OXFORDSHIRE COUNTY COUNCIL'S RESPONSE TO CONSULTATION ON THE FOLLOWING DEVELOPMENT PROPOSAL

Application no: 22/03063/F

Proposal: Erection of 126 dwellings with access from Camp Road, provision of public open space and associated infrastructure.

Location: Land East Of Larsen Road, Heyford Park

Engineering Plan

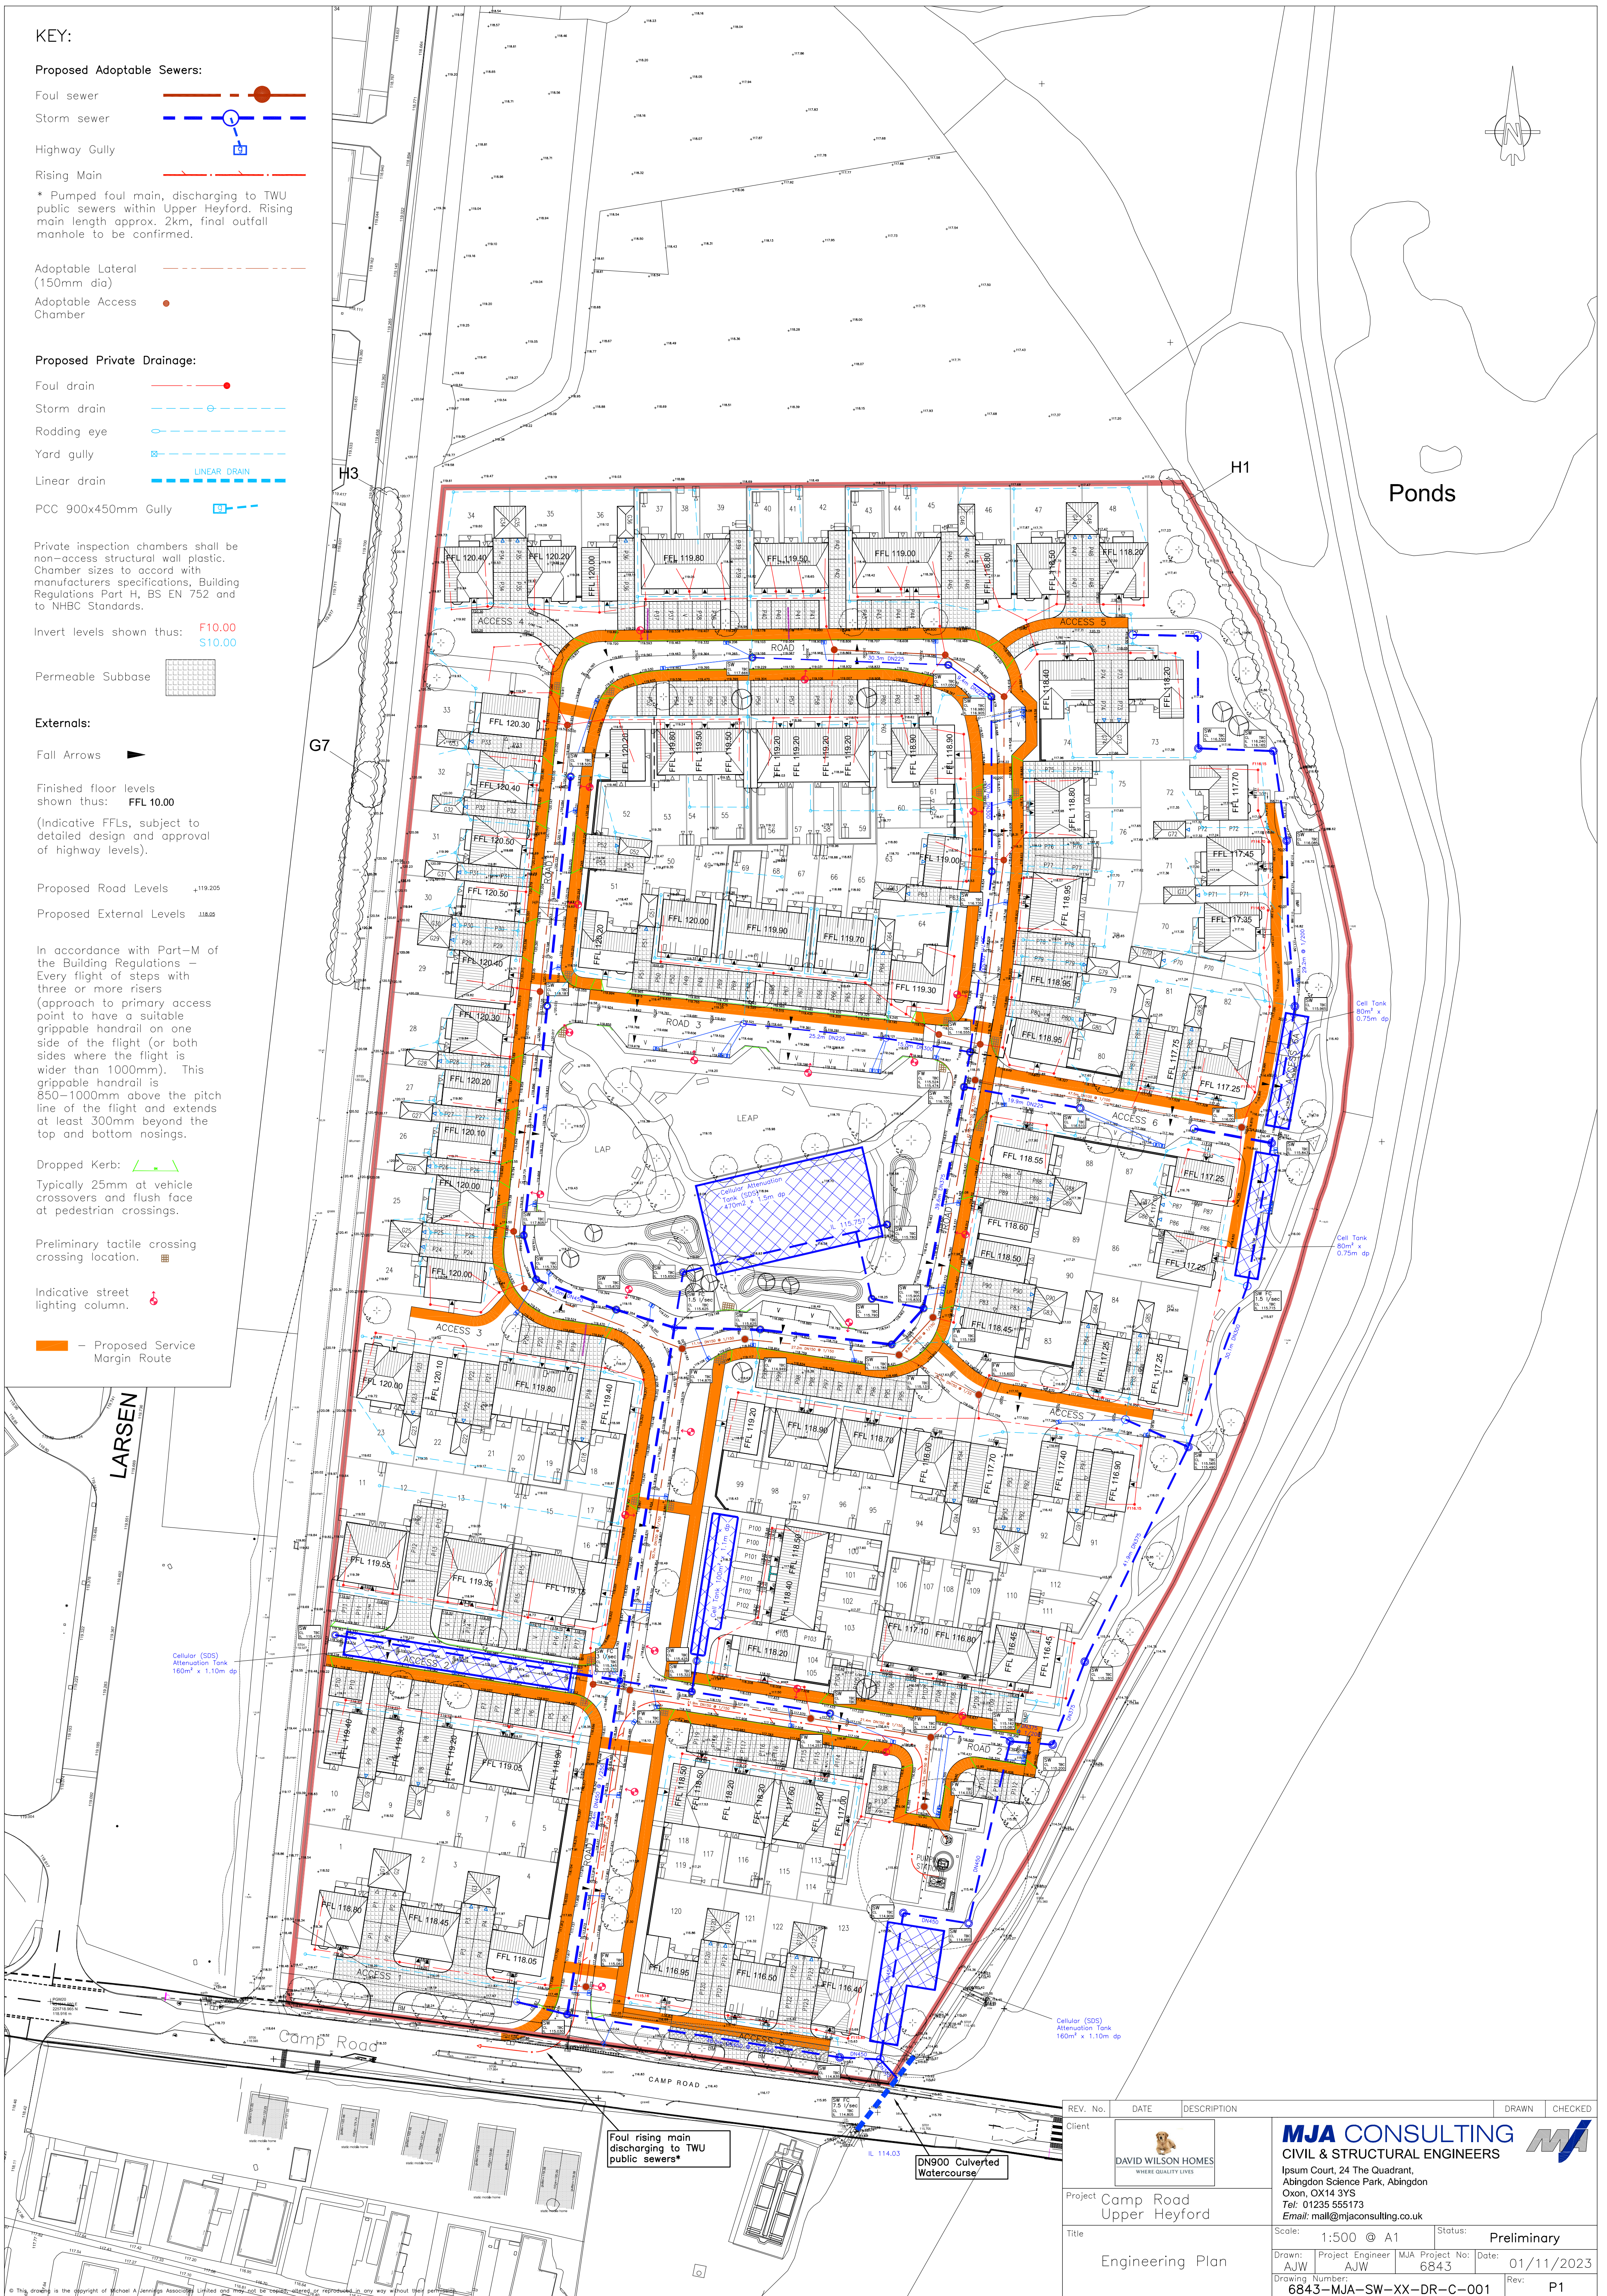
A footpath link to Larsen Road / Trenchard Circle has been included on the drawings, as requested. This, along with the link on the east side of the site, is denoted as a “Hoggin Footpath”. Details of the footpath construction are requested by condition to ensure that the path is suitable for all users. A proposed condition is as follows:

Where the existing track passes through the eastern boundary (circled in pink, above), the opening needs to be secured to ensure that a continuous off-road cycle route is possible. The area leading up to the opening is shown as grasscrete on the General Arrangement drawing no. 2099.16/01, Rev. J (submitted 31 October 2023, extract below). This system should only be used if it can be demonstrated that it is suitable for cycling over.

Drainage strategy drawing (DRG NO.22-192-100, Rev C) provided and does not address the comments below. Drainage connections around the plots from and to the permeable needs to be shown.

All the drainage infrastructure around the private plots needs to be shown. Provide invert and cover levels of all SuDS/drainage infrastructure. Include pipe gradients and pipe numbering which should read in line with the calculations.

“Prior to the commencement of the development hereby approved, full details of the footpath links to the north of Plot 36 and to the east of Plot 85 shall be submitted to and approved in writing by the Local Planning Authority. Thereafter, the footpath links shall be constructed and retained in accordance with the approved details.”

“Prior to the commencement of the development hereby approved, full details of the opening through the boundary in the south-east corner of the site, and the surfacing of the track leading up to the opening, together with a timetable for its delivery, shall be submitted to and approved in writing by the Local Planning Authority. Thereafter, the opening and the track shall be constructed and retained in accordance with the approved details and timetable.”
